Permit Number: 080252

This is to certify that OLD PORT RETAIL HOLDING LLC/H... Management Group
 has permission to Inlarge existing restaurant (51 Wharf) into "previous Thai'd in spots"
 AT 436 Fore St / 57 wharf CB# 032-R007001

Proposed Use: Commercial - 51 Wharf - Inlarge existing restaurant (51 Wharf) into the previous "Thai'd in Knots"	Proposed Project Description: Inlarge existing restaurant (51 Wharf) into the previous "Thai'd in Knots"
--	--

Dept: Building **Status:** Approved with Conditions **Reviewer:** Jeanine Bourke **Approval Date:** 10/17/2008

A100

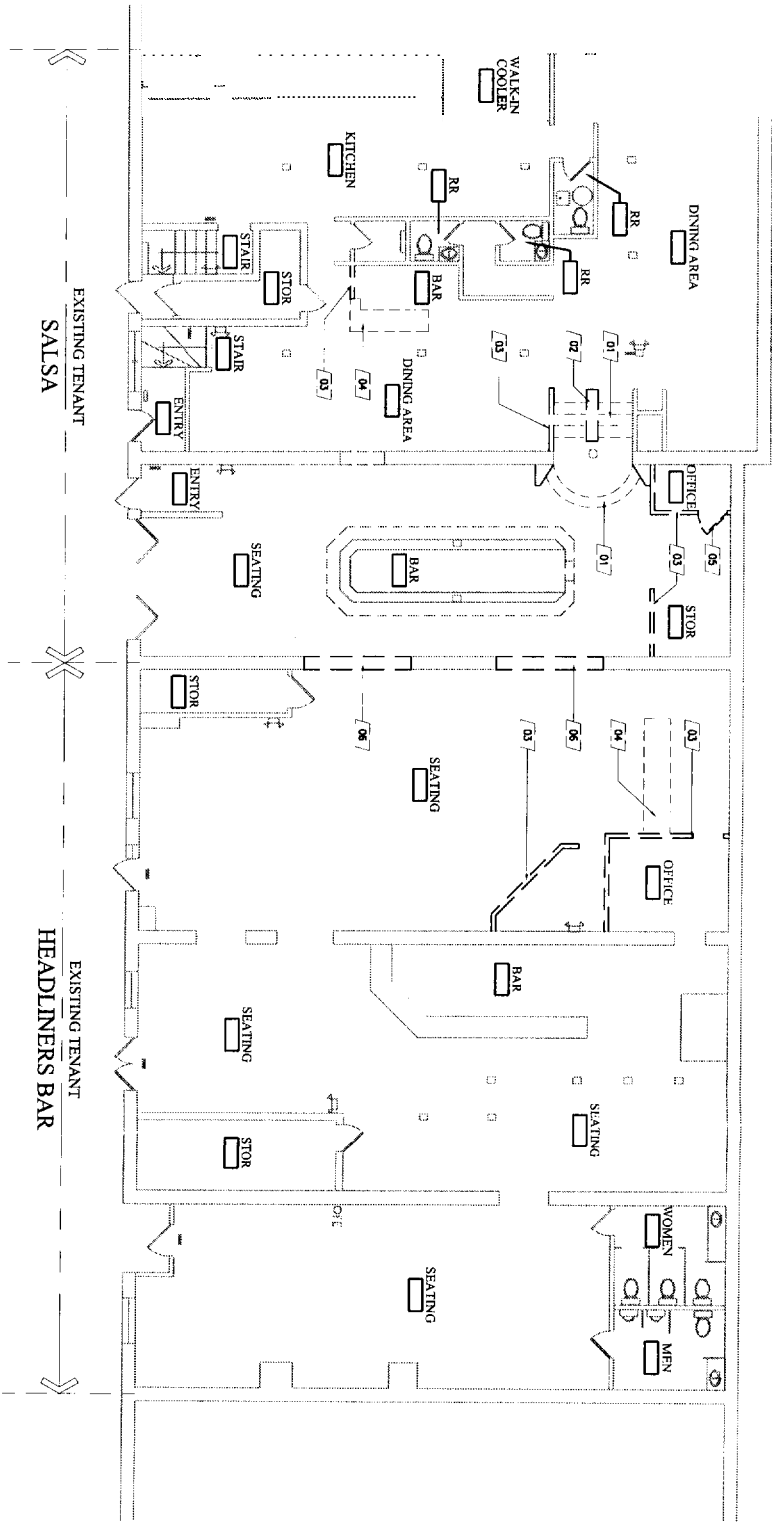
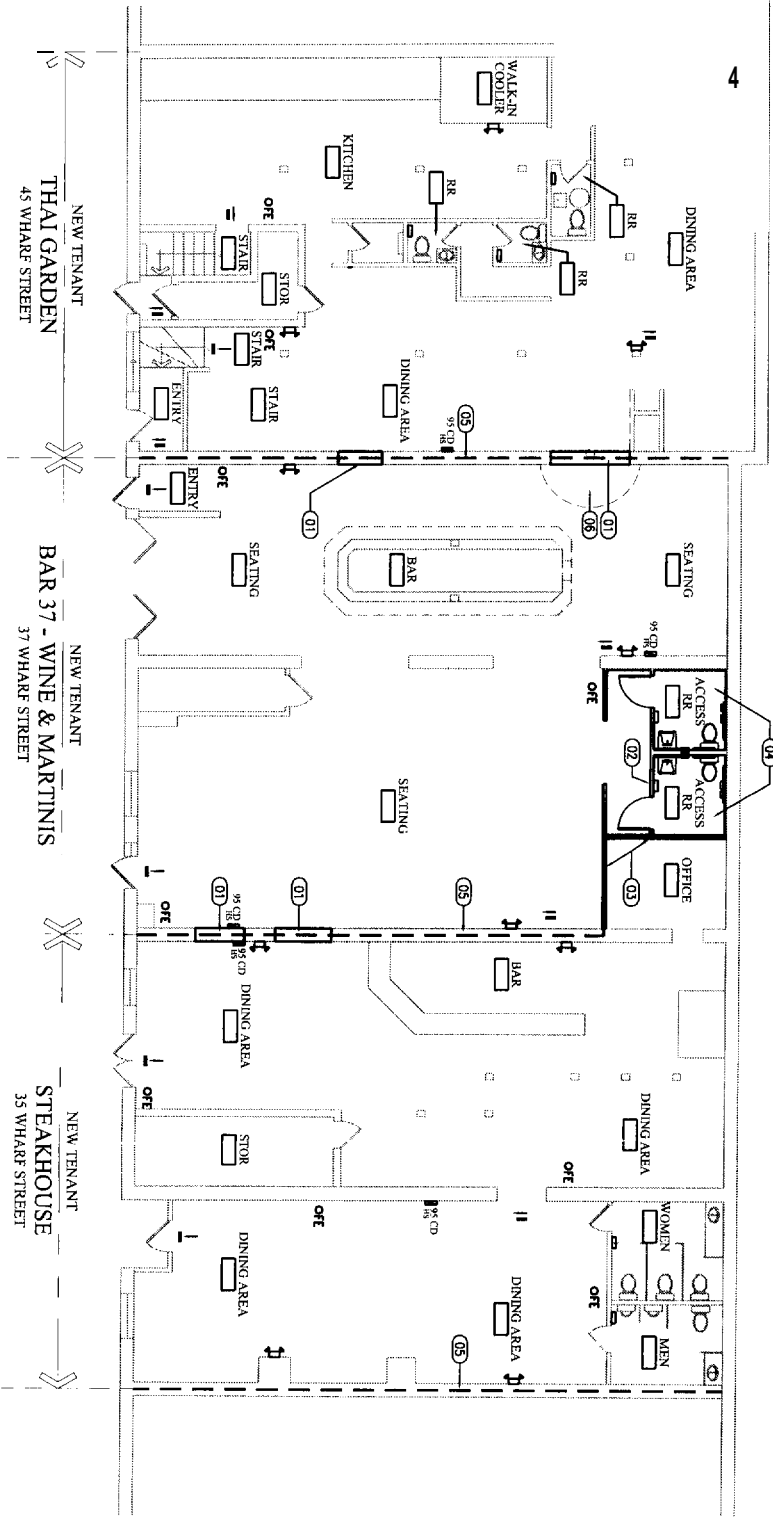
- 4) The existing bathrooms may be removed after the new ones are installed. Fixture count is met on approved plans. No work on the new entry stair reconfiguration or DJ booth is permitted.

10/2/2008-jmb: Spoke with Tanner about occupant load, he stated under 299. For bathroom fixture count he changed one of the urinals to a water closet. The required amount is 3 for each gender. Also discussed the storage closet under the stairs to the floor above, this closet will need to be fire protected.

10/17/2008-jmb: Spoke to Tanner about proposed plans for reconfiguration of the entry steps and DJ booth. He will submit this for a future permit. He would like to remove existing 2 bathrooms near the kitchen, ok as the required fixture count is met with the new bathrooms.
